Recommendation Report for Planning Permission for Works or Extension to a Dwelling

REF NO: FG/84/20/HH

LOCATION: 15 Langbury Lane
Ferring
BN12 6PU

PROPOSAL: Single storey side (east) extension & extension to roofspace to convert to habitable use including rear (south) dormer & side (east) dormer window, 4 No rooflights to front (north) & 1 No rooflight to side (east) elevation.

Proposed floor plans

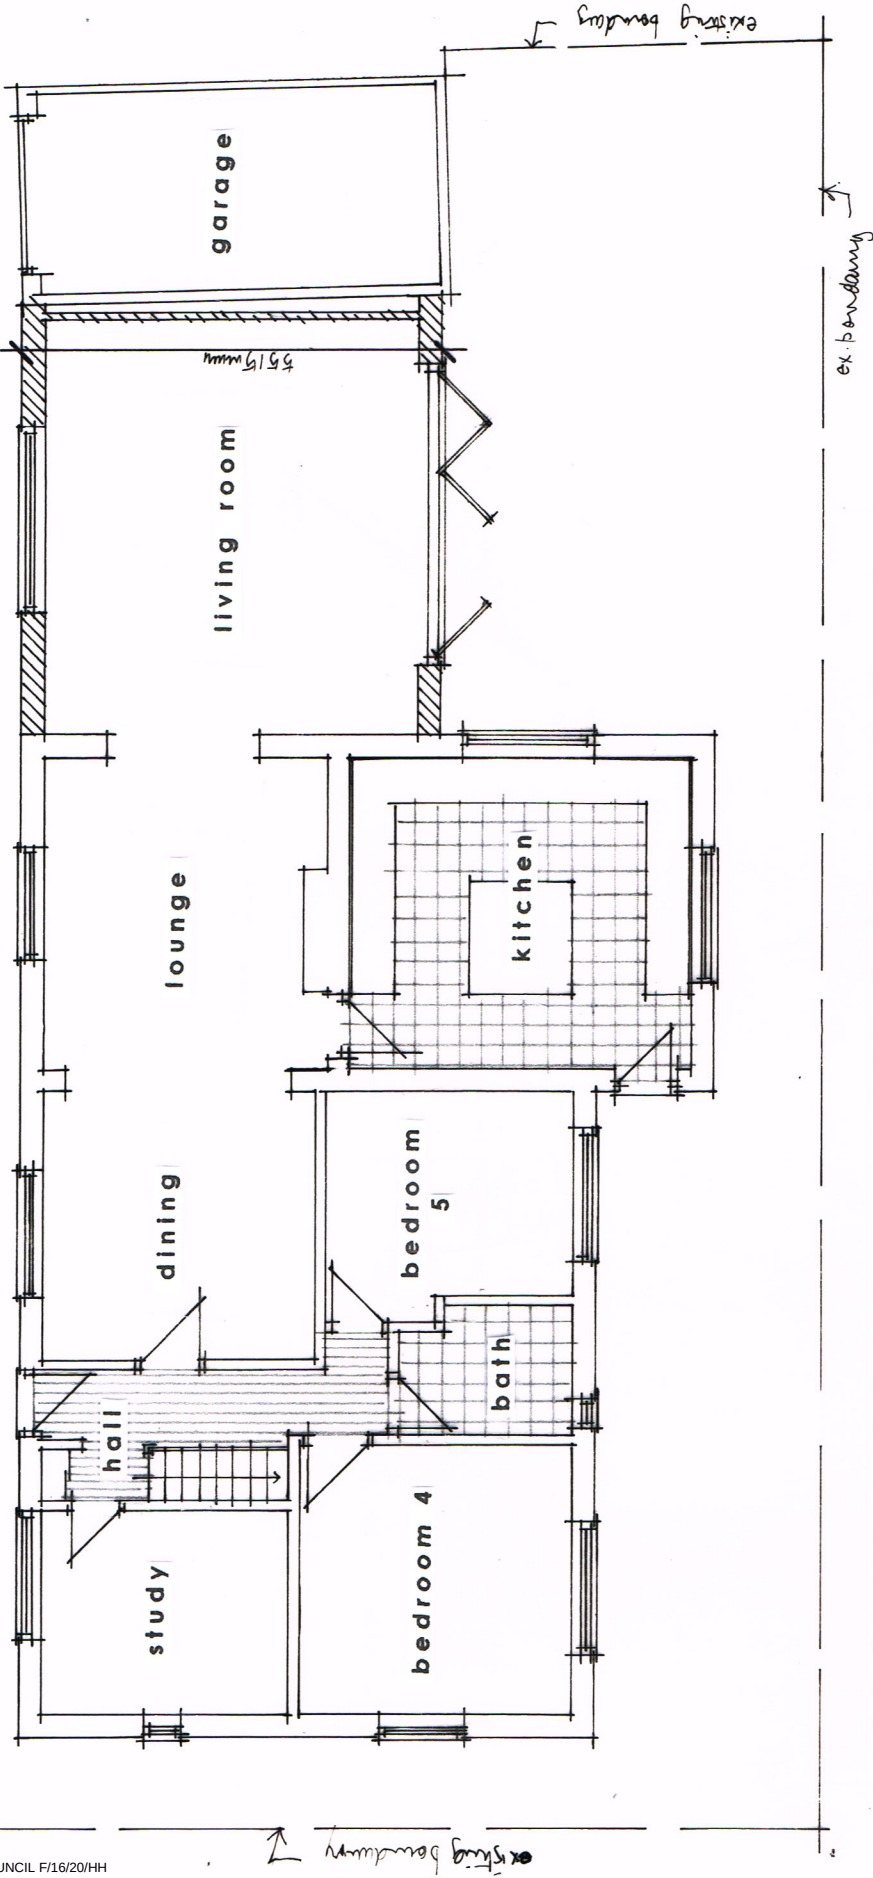
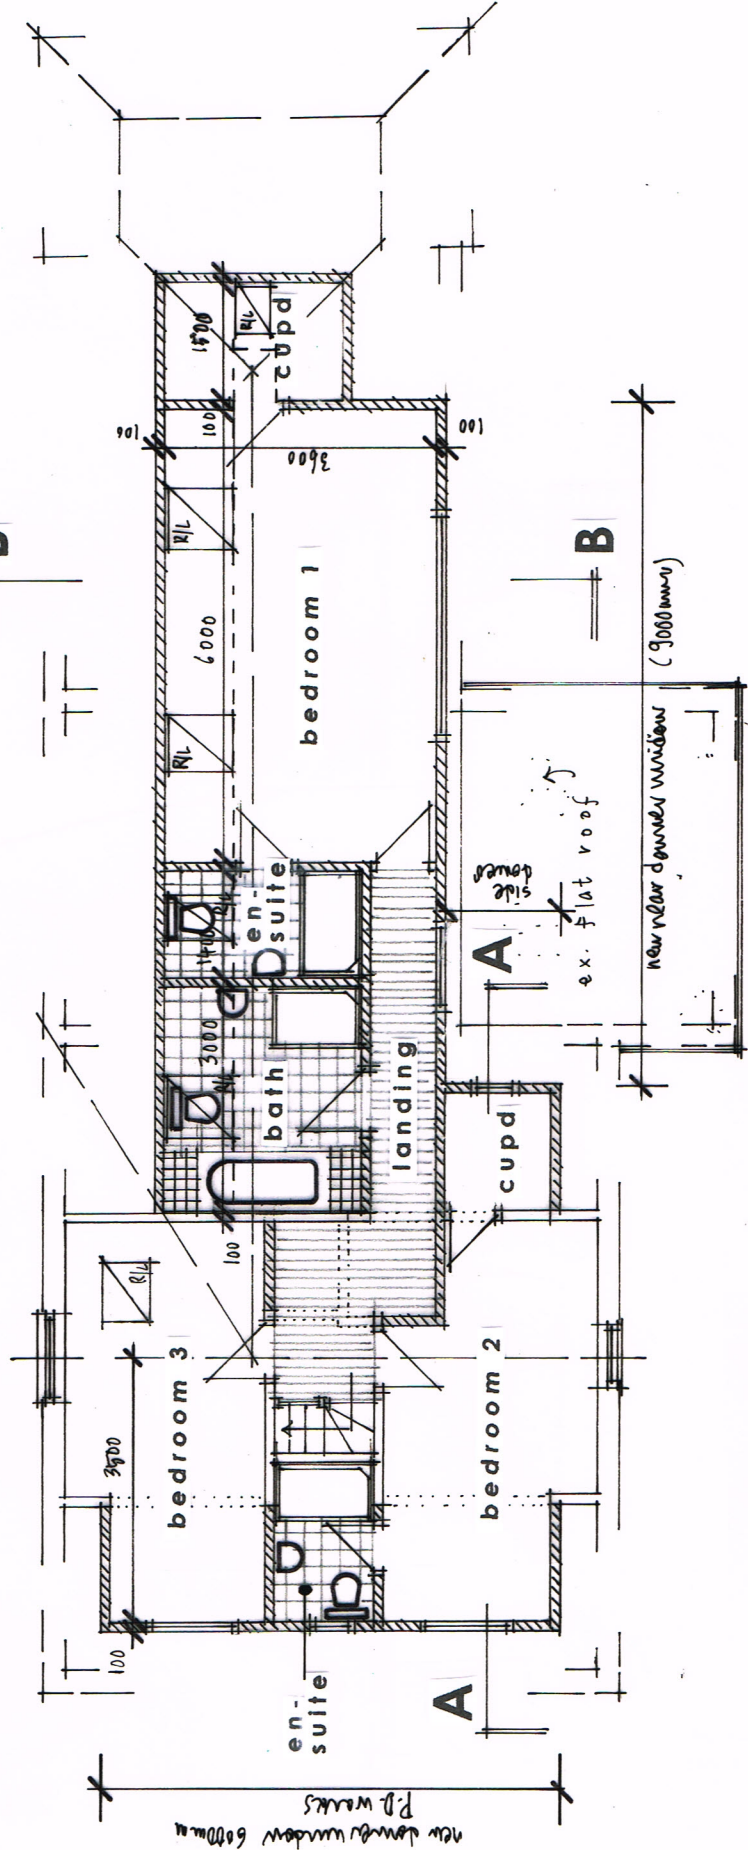
Proposed Elevations dwg.no.FG/LL/04 dated July 2020
Proposed Floor Plans dwg.no. FG/LL/03 dated July 2020

PROPOSED ELEVATIONS 1:100

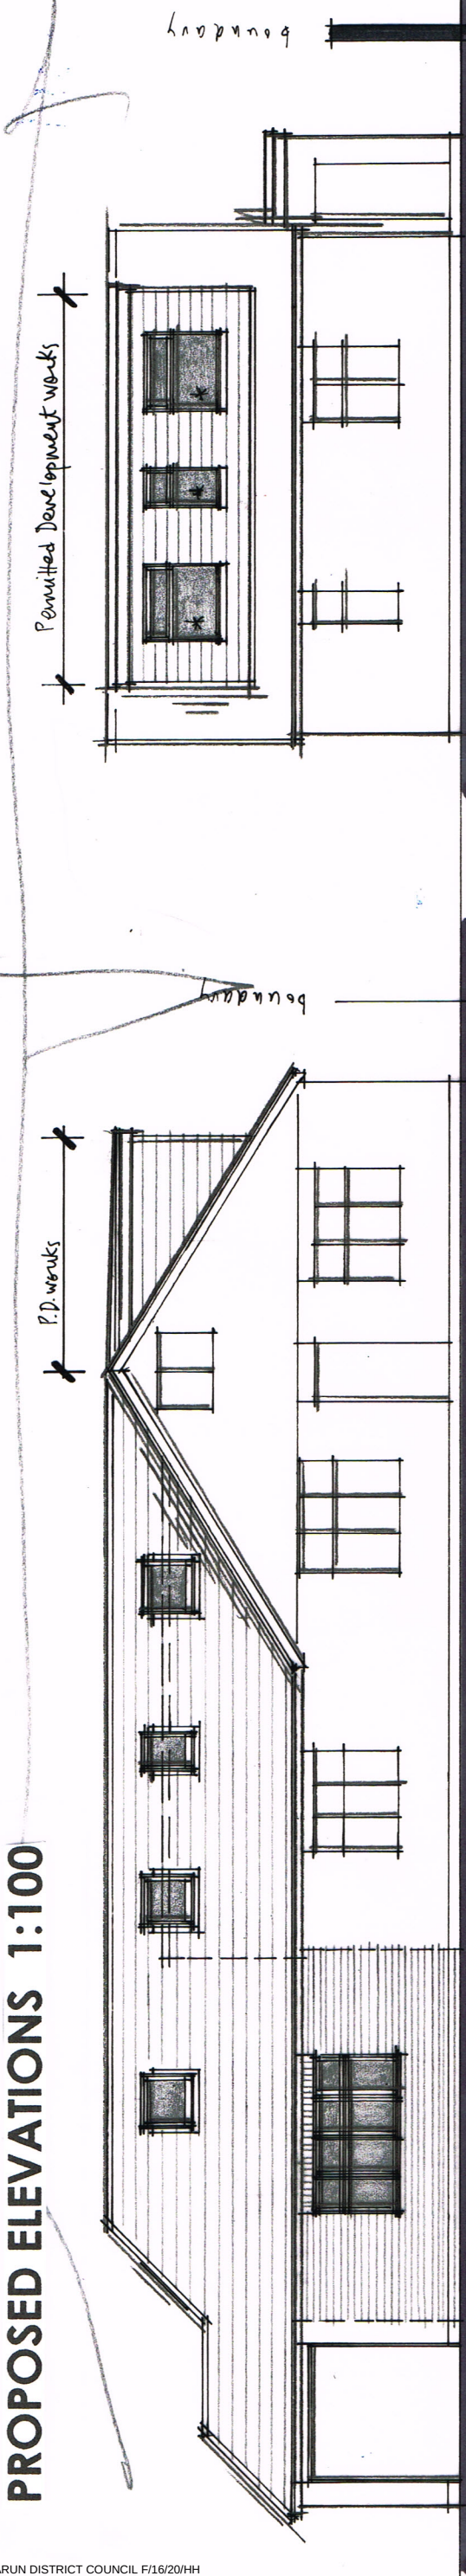
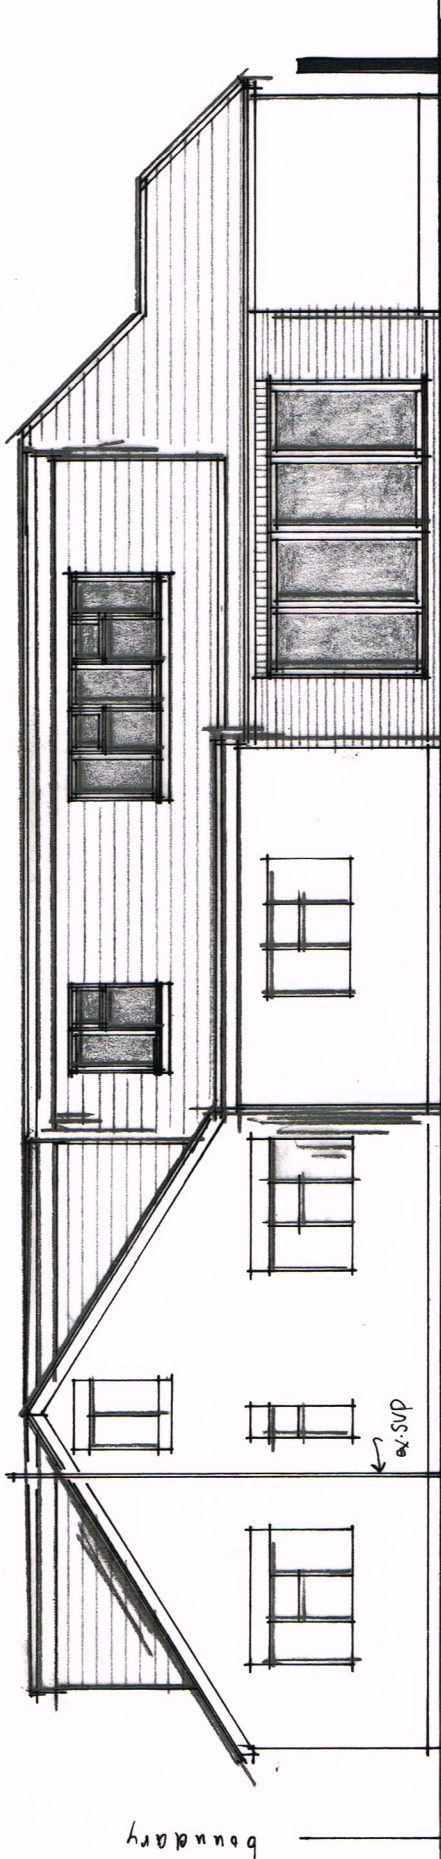
The proposed side extension by virtue of its scale and design would not impact on the neighbouring dwellin in terms of a loss of light or an overbearing impact. However the side facing eastern elevation would have a window in it which has the potential to overlook 11 Langbury Lane and therefore it is proposed to impose a condition requiring the window to be obscure glazed and fixed shut.

- 3 The upper windows on the east elevation of the building shall at all times be glazed with obscured glass and fixed to be permanently non-opening up to 1.7m above finished floor level.
